## Engineers Comments Regarding Surface Water Drainage

<b>Application Reference:</b>	LU/96/25/PL	<b>Reviewer Reference:</b>	ADC/PC
<b>Planning Officer:</b>	Harry Chalk	<b>Date of Review:</b>	18/09/2025
<b>Site Name:</b>	16 Swanbourne Road Littlehampton BN17 6HS		
<b>Application Description:</b>	Erection of 1 No. single storey, self-build dwelling with car parking to include provision of driveway and car parking for No.16 Swanbourne Road. This application is in CIL Zone 4 and is CIL Liable as a new dwelling.		
<b>Assessment Number:</b>	1 of 1

- FOUL & SURFACE WATER DRAINAGE REPORT REV P1 (C3489)

- STANDARD DRAINAGE NOTES
- DO NOT SCALE FROM THIS DRAWING. REFER TO FIGURED DIMENSIONS ONLY. THE CONTRACTOR SHOULD CHECK ALL DIMENSIONS ON SITE.
  - ALL DIMENSIONS IN MILLIMETRES AND ALL LEVELS ARE IN METERS UNLESS NOTED OTHERWISE.

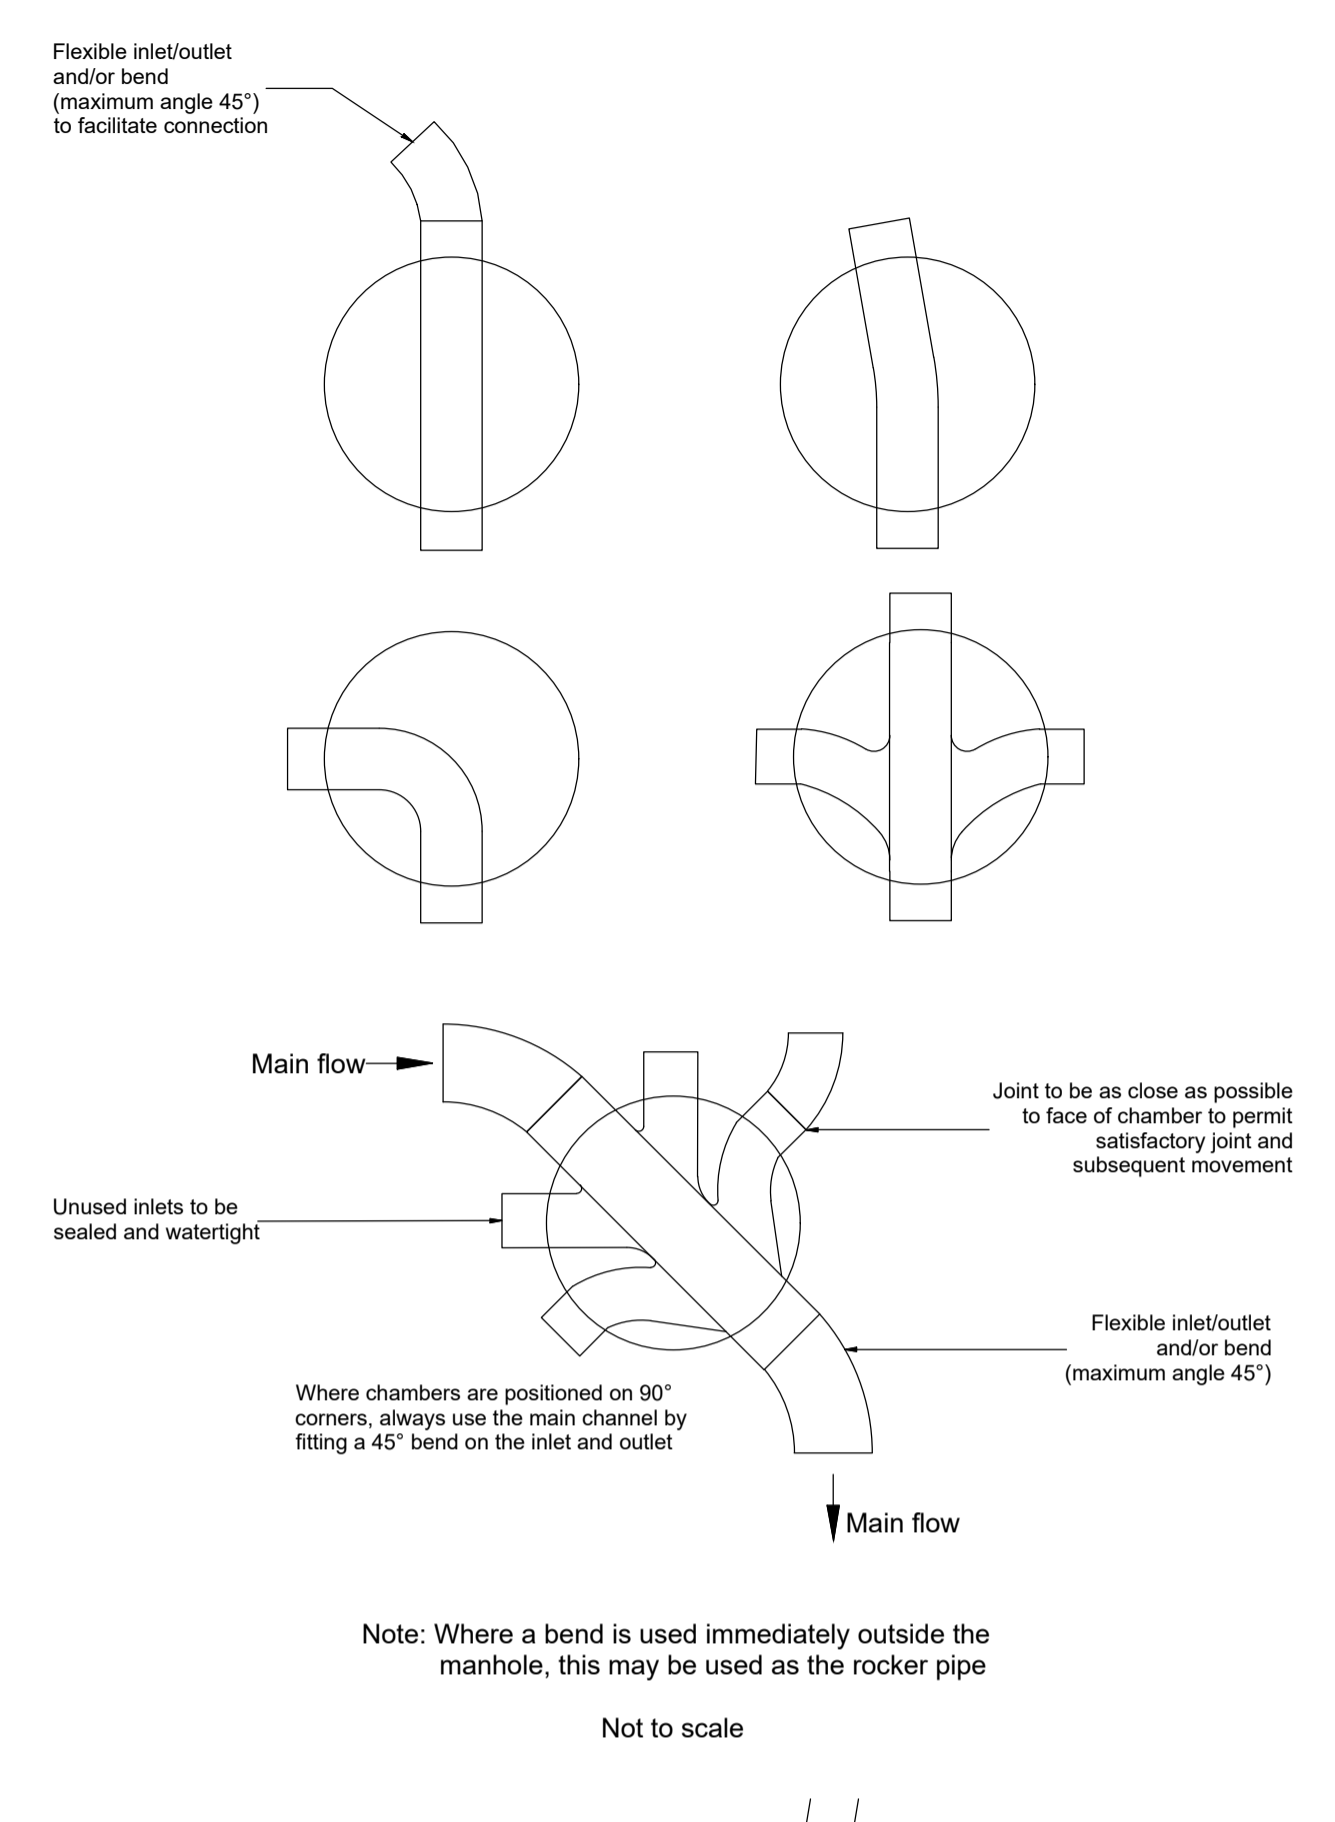
We suggest that the silt trap construction detail is adjusted so that the 300mm dimension is from the pipe invert to sump base.
